120 Laund Road, Salendine Nook, Huddersfield - Discharge of conditions 4 (drainage scheme) and 5 (drainage scheme) on previous permission 2014/93584 for demolition of dwelling and erection of 10 dwellings

1) The drainage details submitted on drawing entitled "DRAINAGE PLAN & DETAILS" (revision p0) dated December 2017 that has been prepared by T J Booth associates are **not** acceptable to Yorkshire Water. The following points should be addressed. For further information, the developer should contact our Developer Services Team (telephone 0345 120 84 82, technical.sewerage@yorkshirewater.co.uk):

DRAINAGE PLAN & DETAILS

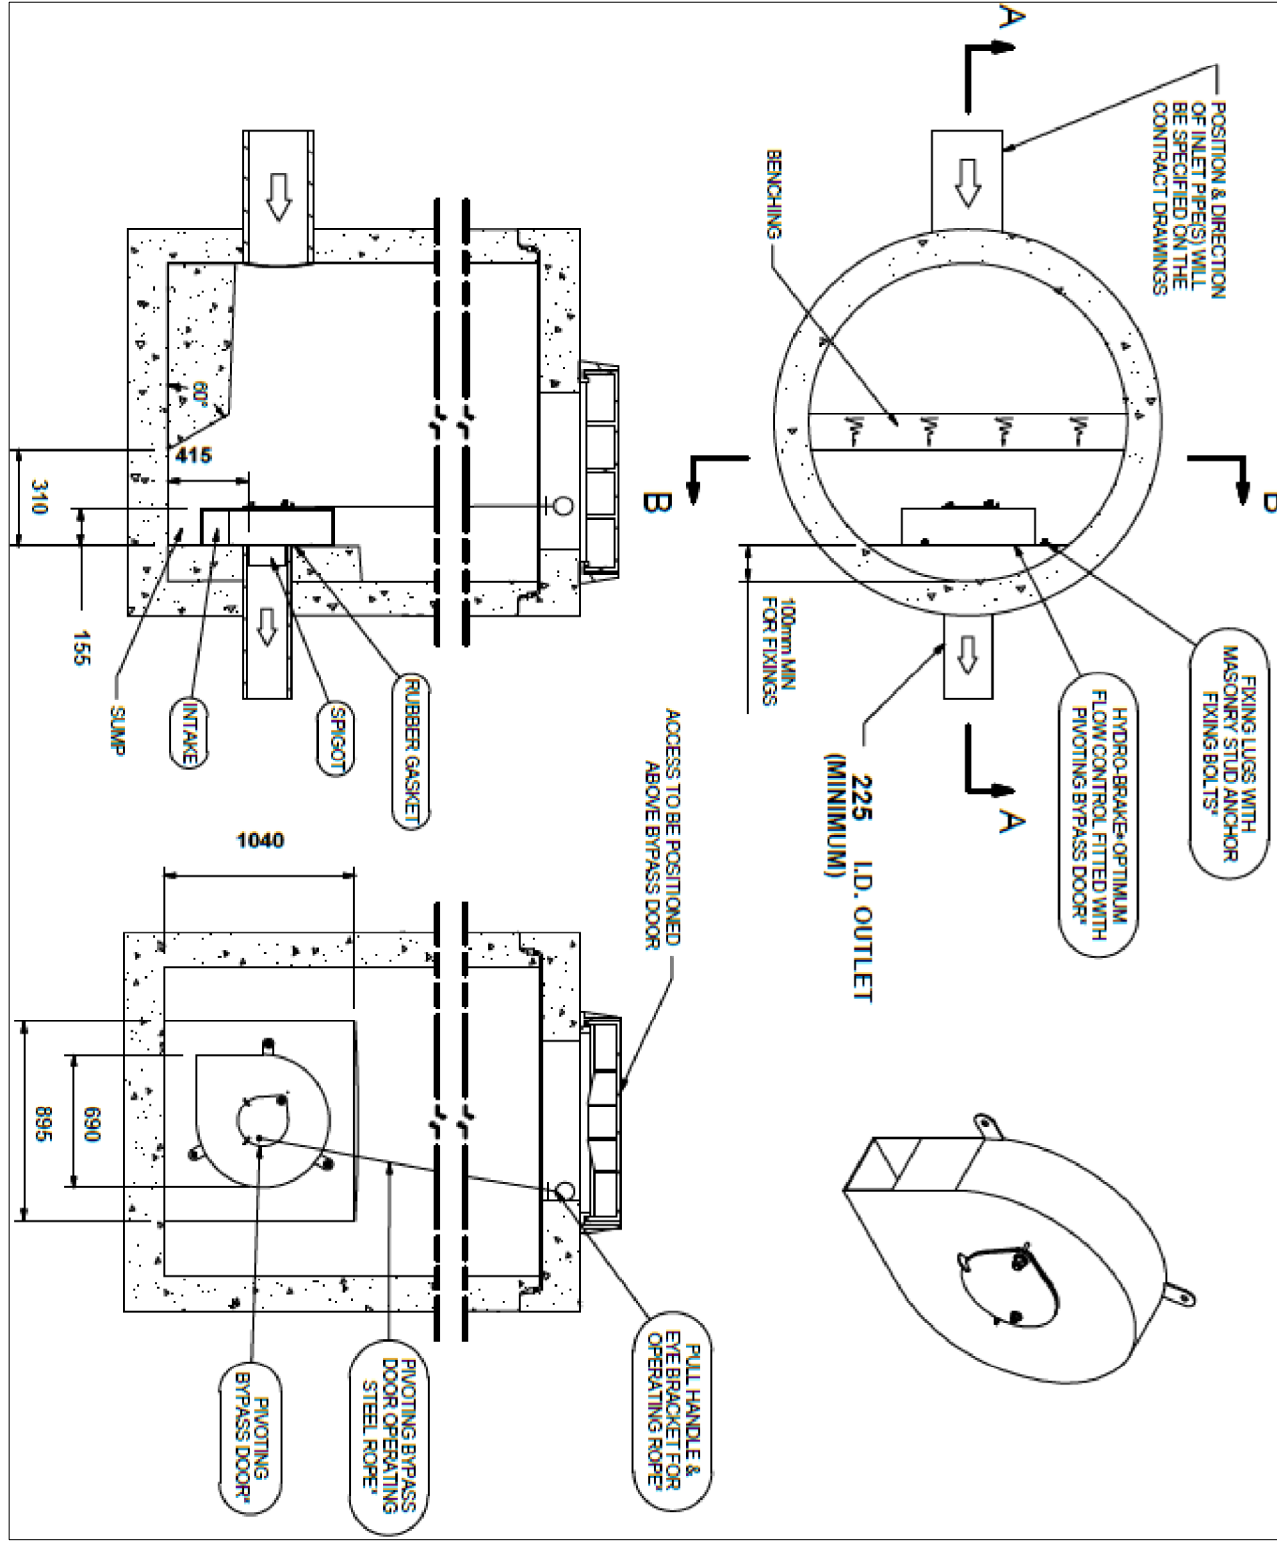
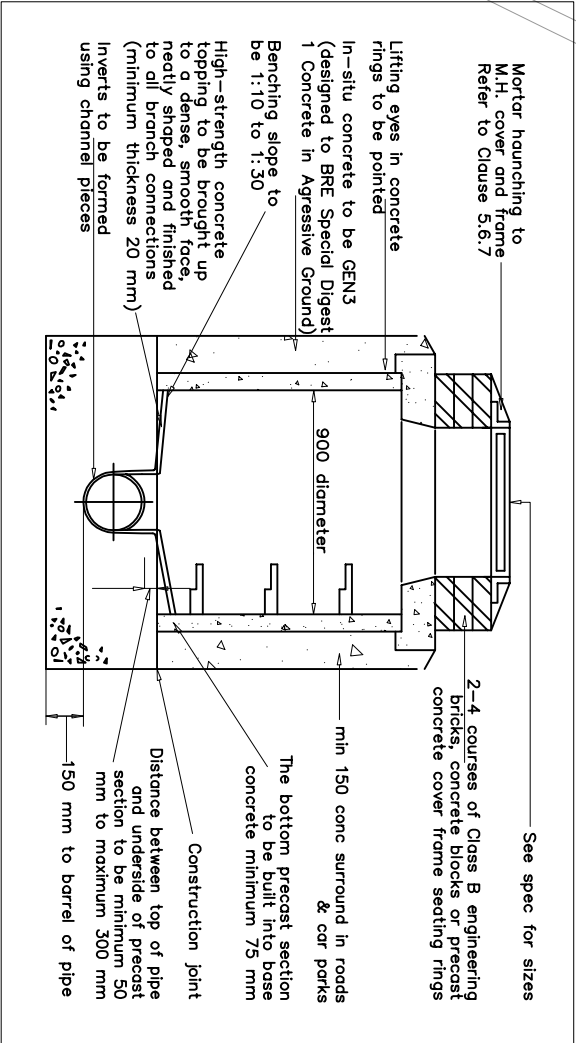
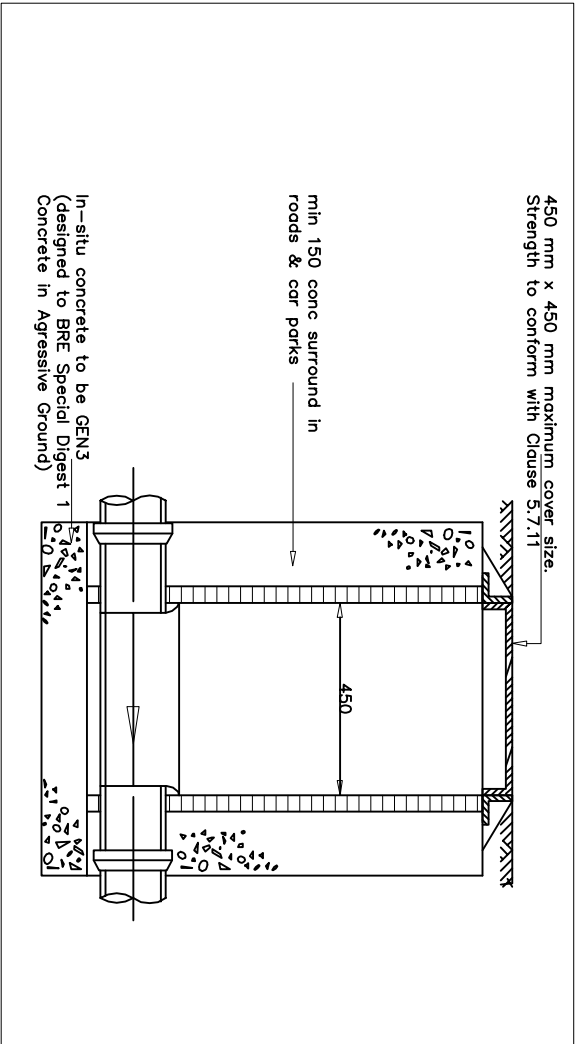
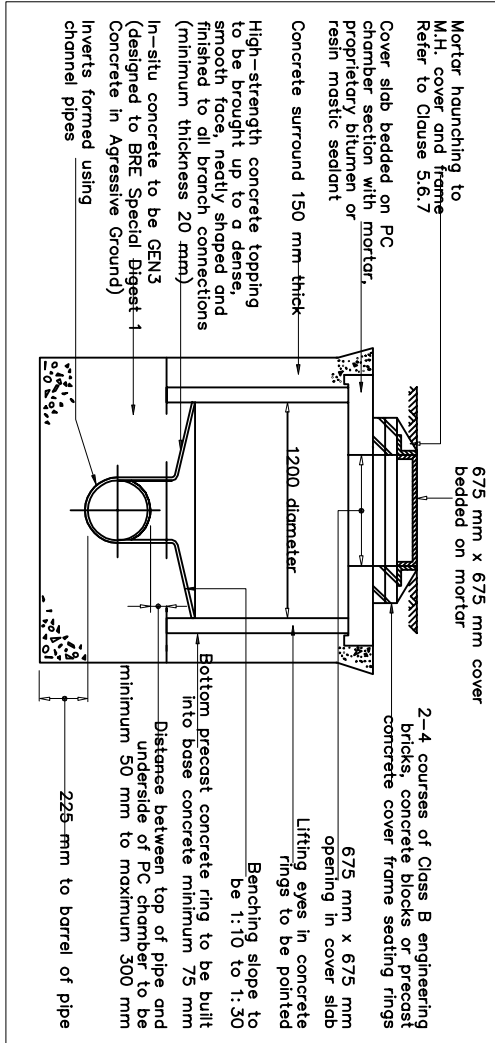
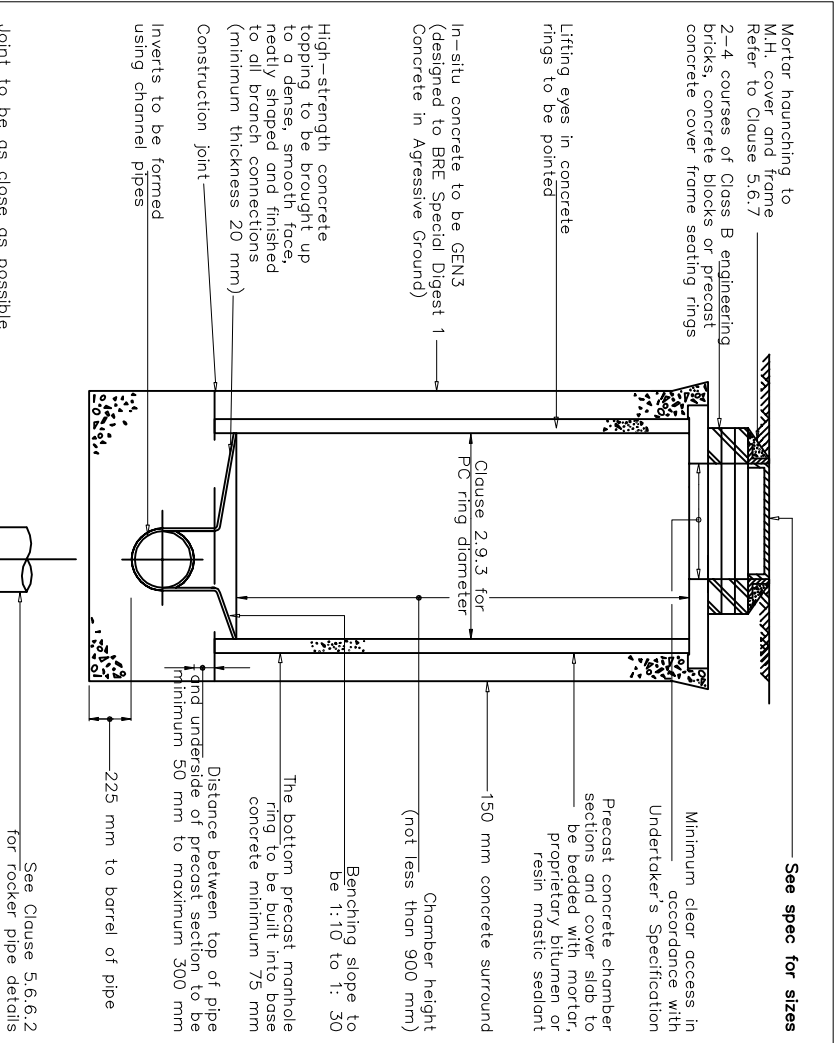
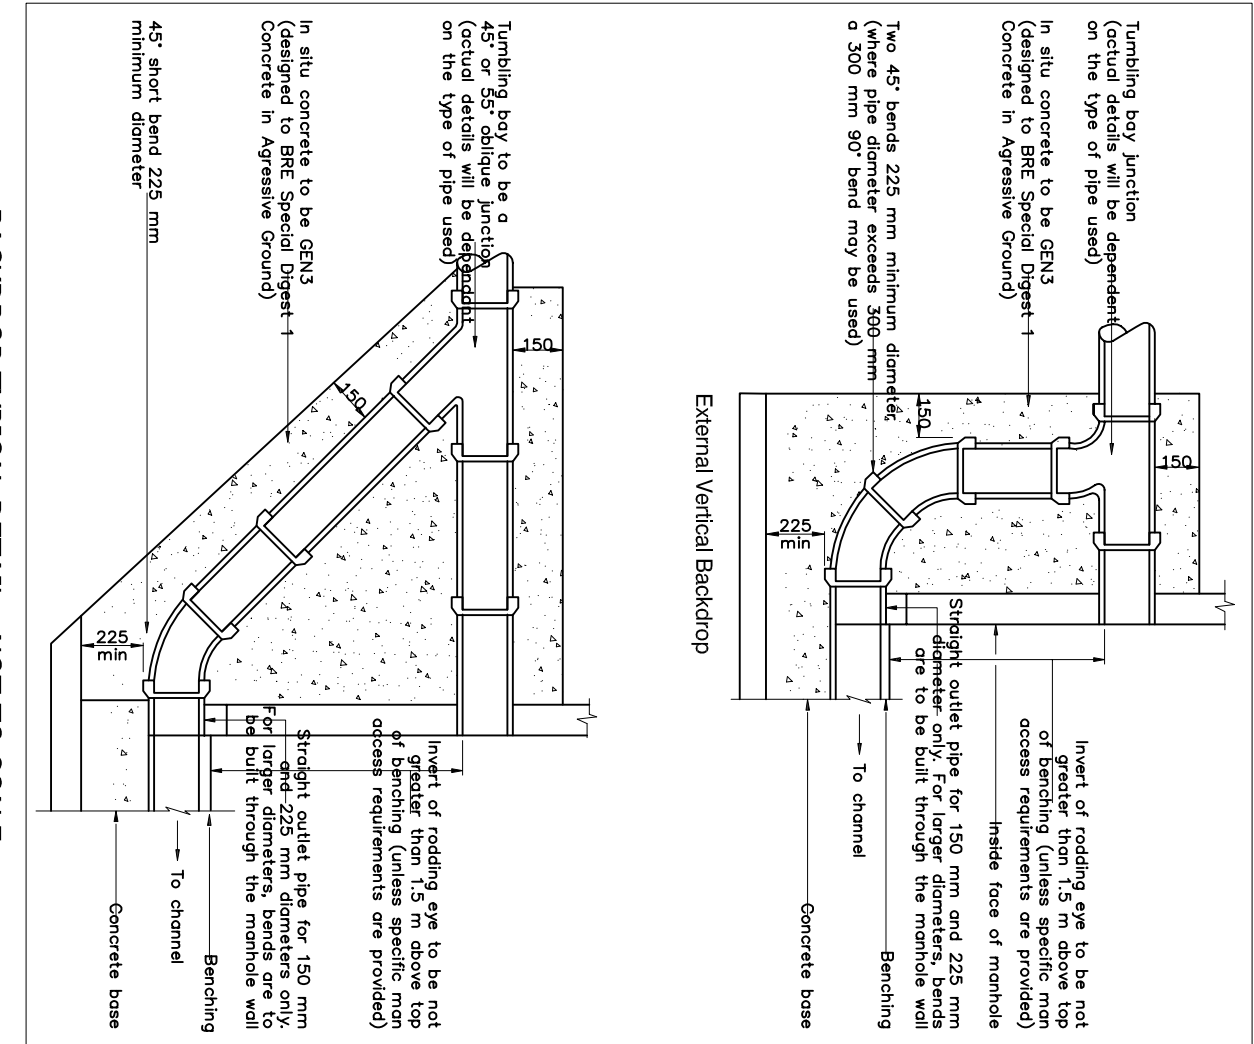
- a) evidence should be submitted to show that other (than discharge to public sewer) means of surface water disposal have been considered and why they have been discounted
- b) evidence of existing impermeable areas positively draining to the public sewer is required to prove rate of discharge

2) The developer is proposing to discharge surface water to public sewer however, sustainable development requires appropriate surface water disposal.

Yorkshire Water promote the surface water disposal hierarchy. The developer must provide evidence to demonstrate that surface water disposal via infiltration or watercourse are not reasonably practical before considering disposal to public sewer.

As a last resort, and upon receipt of satisfactory evidence to confirm the reasons for rejection of other methods of surface water disposal, curtilage surface water may discharge to public sewer. Surface water discharges to the public sewer must have a minimum of 30% reduction based on the existing peak discharge rate during a 1 in 1 year storm event.

The developer will be required to provide evidence of existing positive drainage to a public sewer from the site to the satisfaction of YWS/the LPA by means of physical investigation. On-site attenuation, taking into account climate change, will be required before any discharge to the public sewer network is permitted.
